**From:** Contact Centre (CRM) <contact@ribblevalley.gov.uk>  
**Sent:** 04 July 2025 15:37  
**To:** Planning  
**Subject:** Planning Application Comments - 3/2025/0133 FS-Case-728633379

**Planning Application Reference No.:** 3/2025/0133

**Address of Development:** Loft Shay , Knowle Green , Longridge

Consultation response to Planning Application 3/2025/0133: Change of use of land to form extension to residential curtilage. Proposed detached garage to include solar panels and living accommodation above. Insertion of second floor side facing window to main dwelling.  
Applicant address: Loft Shay Farm, Knowle Green, Nr. Longridge, Preston PR3 2YQ

Proposed Elevations Revision D

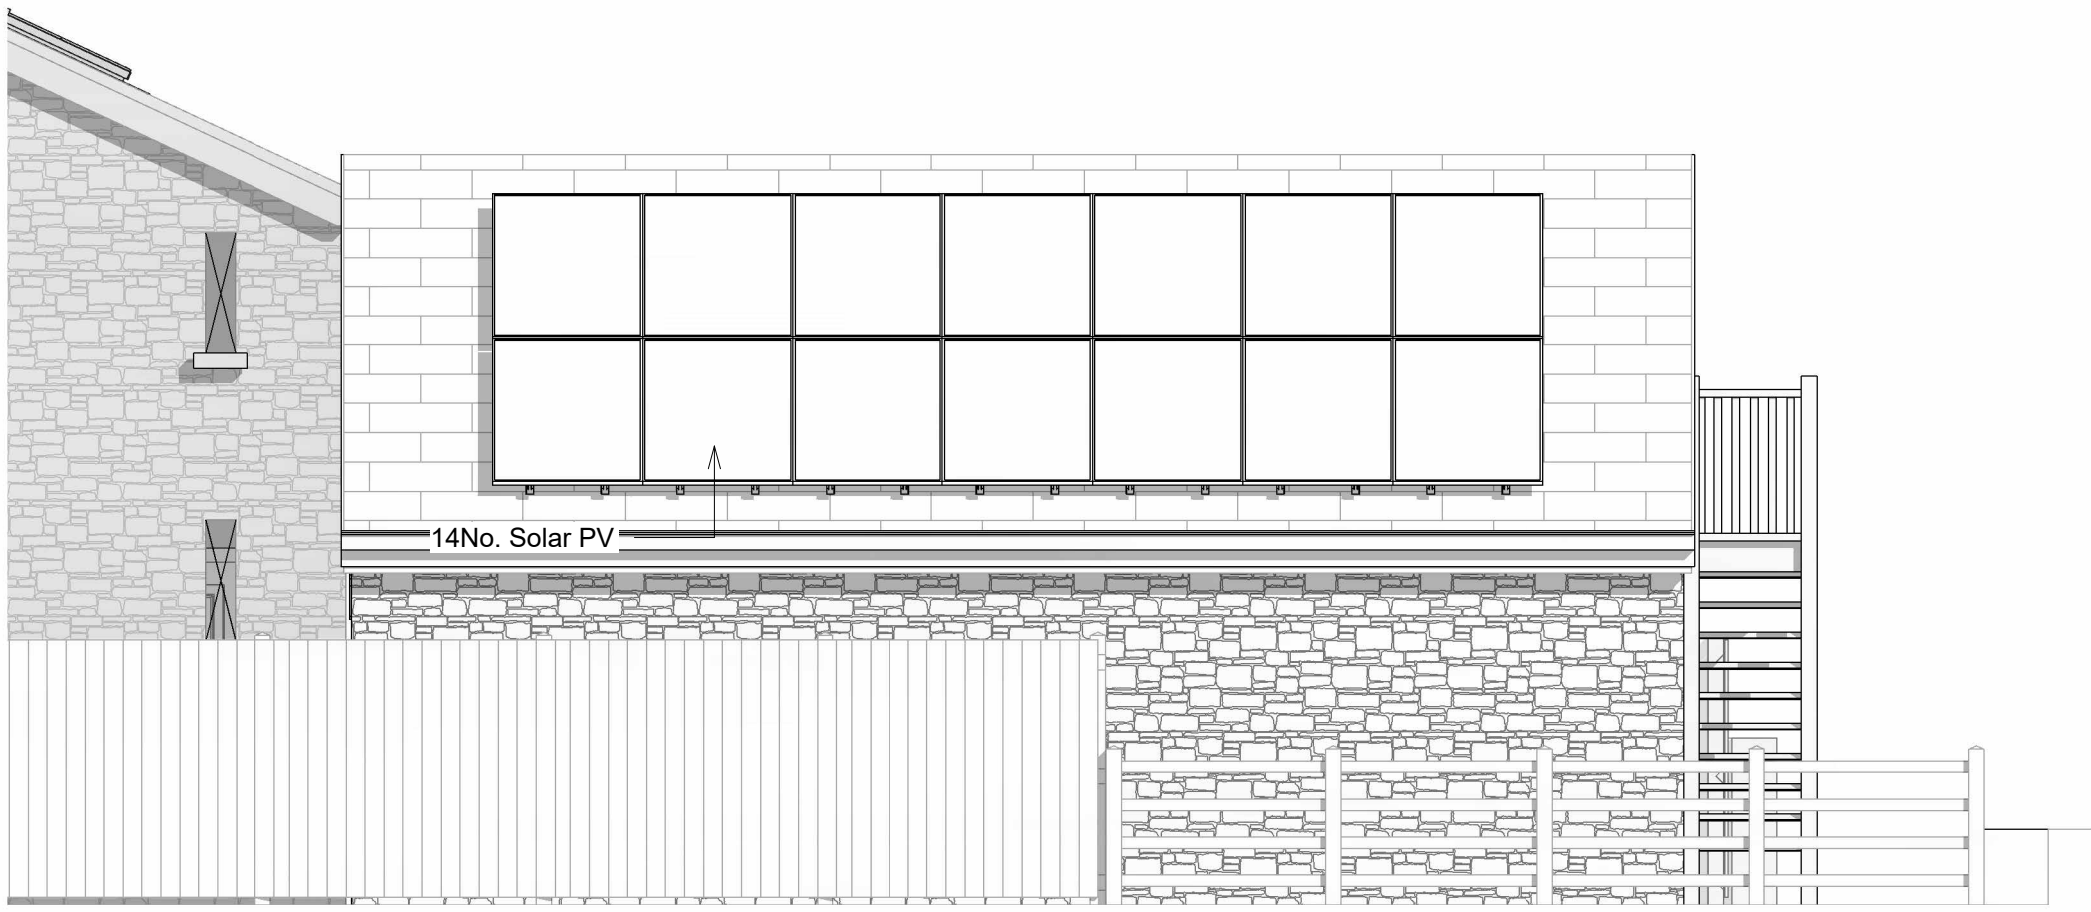
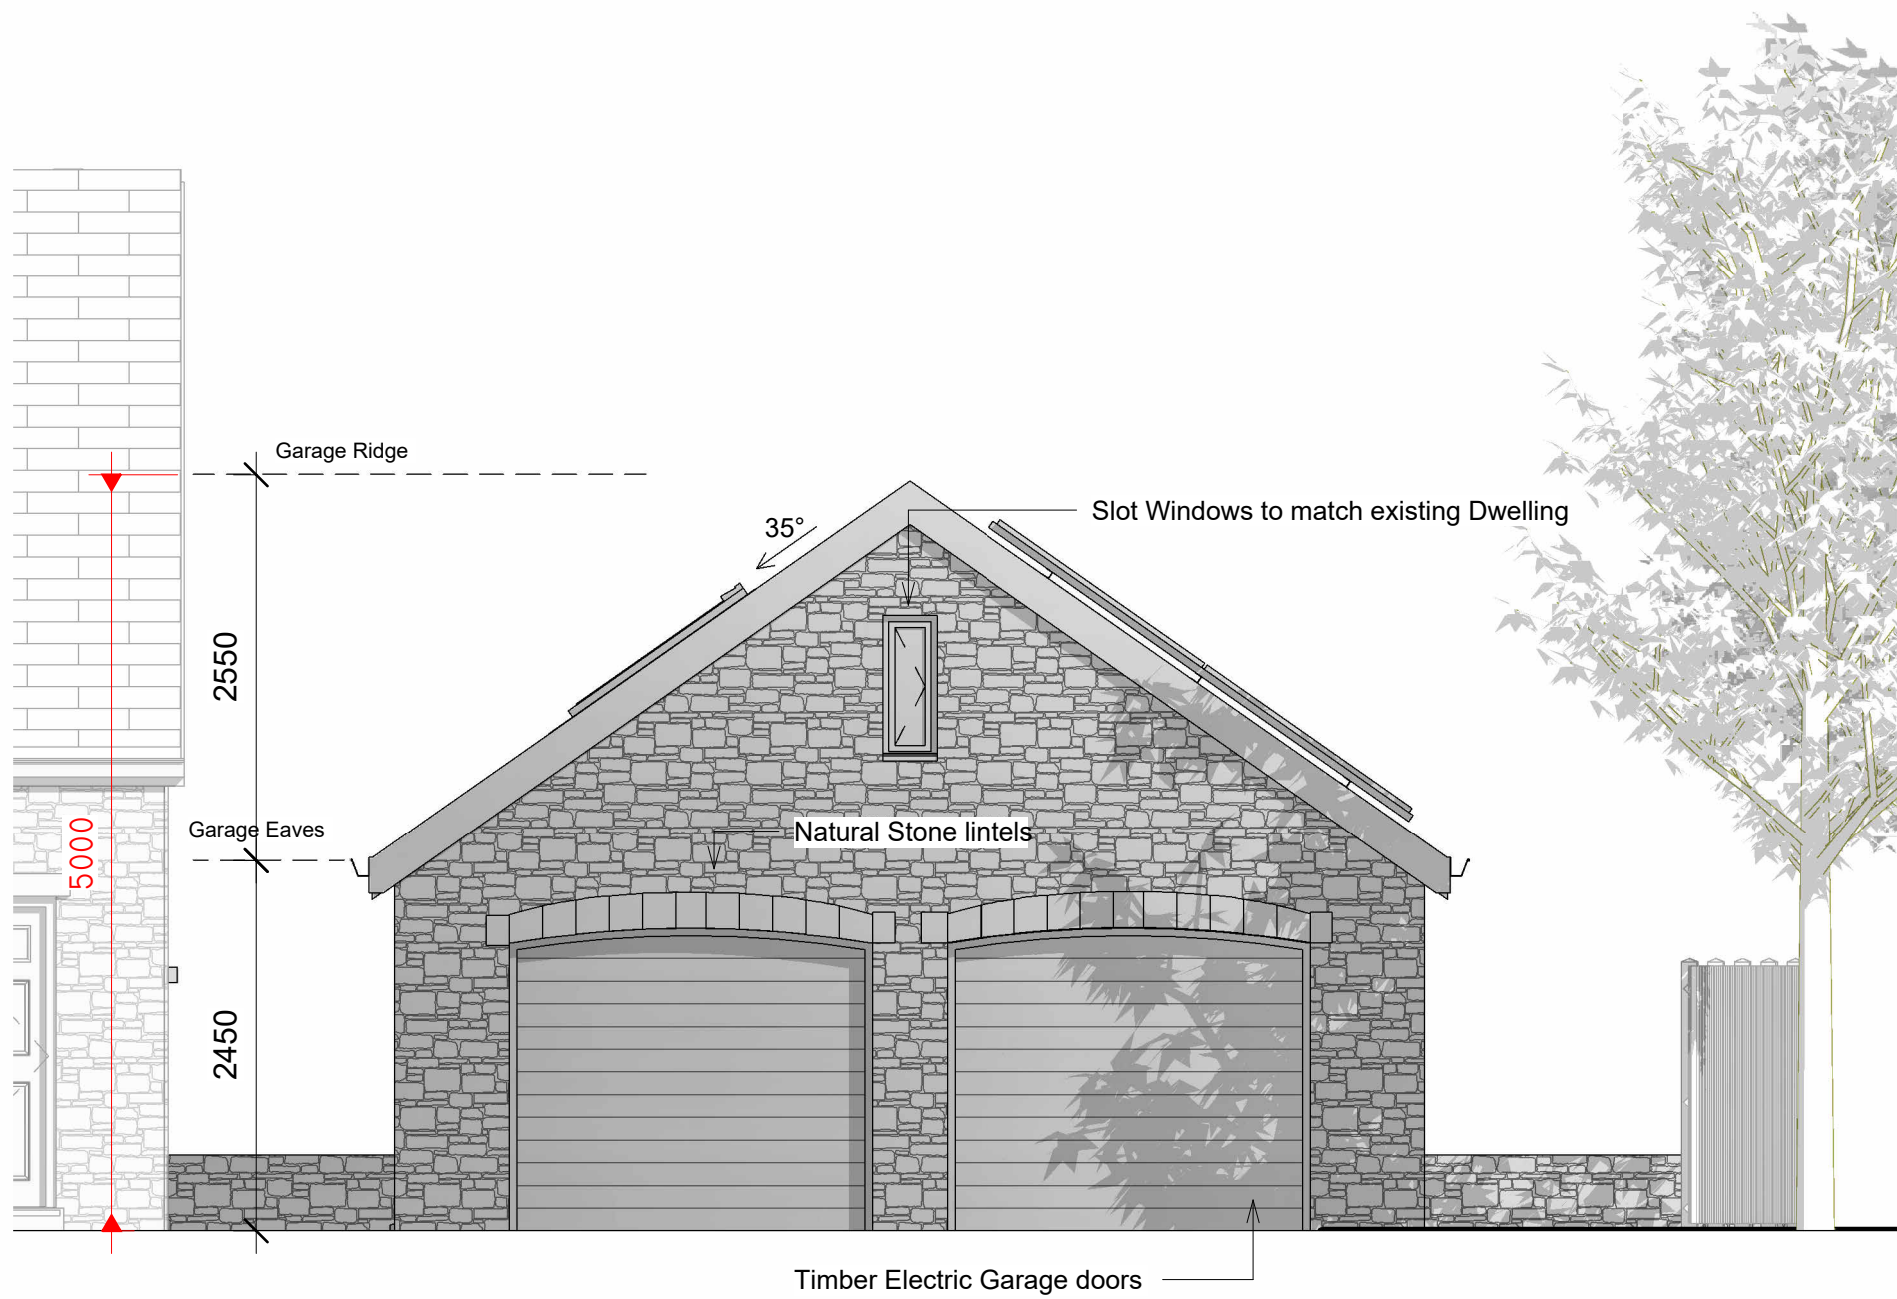
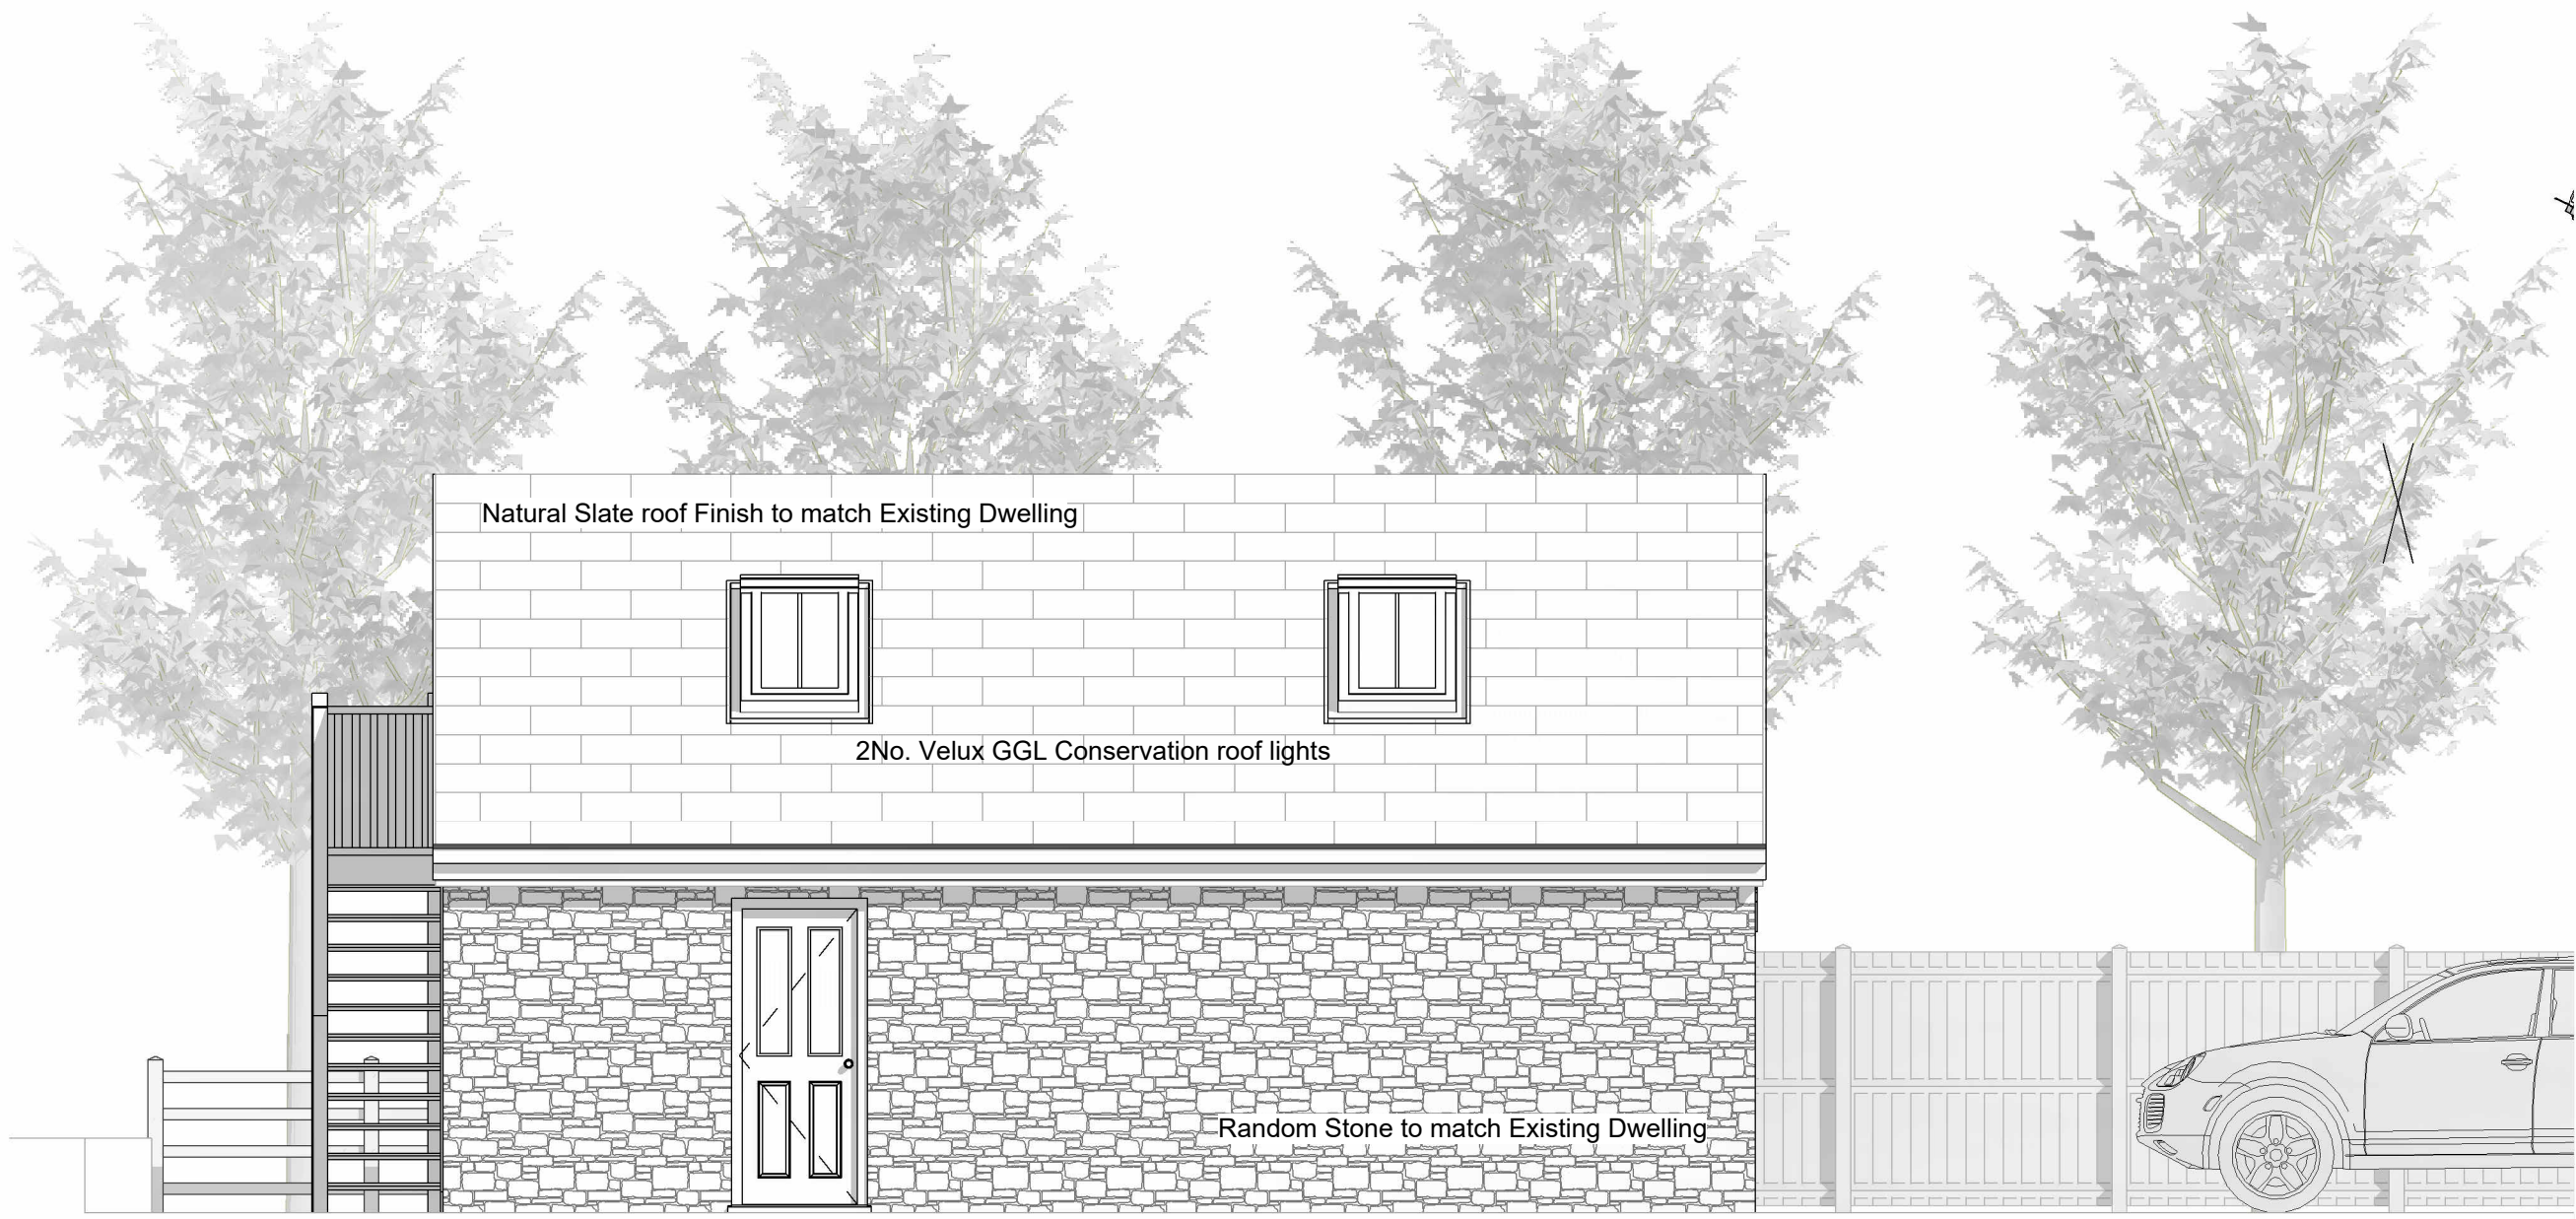
The external staircase at the back of the building constitute a privacy issue : they overlook the adjacent private residential property, giving a clear view of the garden and inside the kitchen and upstairs bedroom of CS DMG1

Secondly, this is a substantial building - some 9m in length, almost 7m wide and 5m high, with two storeys and living accommodation on top, with stairs at the rear for access to the first floor, set back from the main dwelling towards the rear of the land owned by the applicant.

Fifth, the application conflicts with CS Key Statement EN2 and CS Policies DMG1, DMG2 and DMH3 in relation to protecting the character, landscape value, protection, conservation and natural beauty of the AONB by adding a 5m tall building, with a completely inappropriate bolt-on stairway, in a

In addition to the above, the external staircase at the rear of the property and entrance to the upper storey rear door also overlooks the neighbouring property's back garden, and potentially the kitchen and upstairs bedroom, resulting in an unacceptable loss of privacy. The National Planning Policy Framework and RVBC Core Strategy guard against this, CS Policy DMG1 stating that all development must "not adversely affect the amenities of the surrounding area," and "provide adequate day lighting and privacy distances."
